January 29, 2025

RE: SP-25-00001

KCPHD has reviewed the application and has comments pertaining to SP-25-00001.

GRAF SHORT PLAT

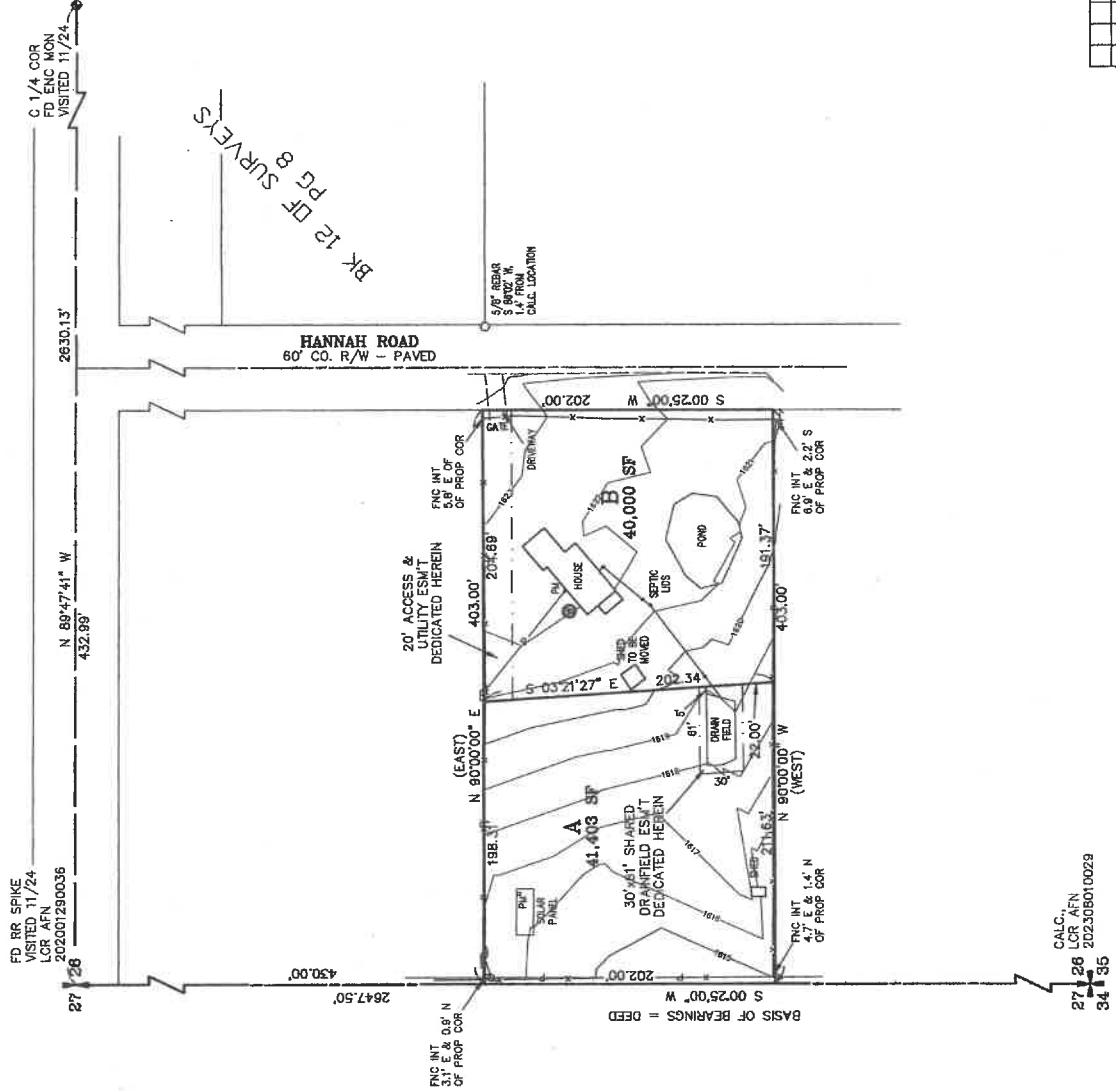
1. Proposed shot plats do not meet minimum land area requirements stated in WAC 246-272A-0320.
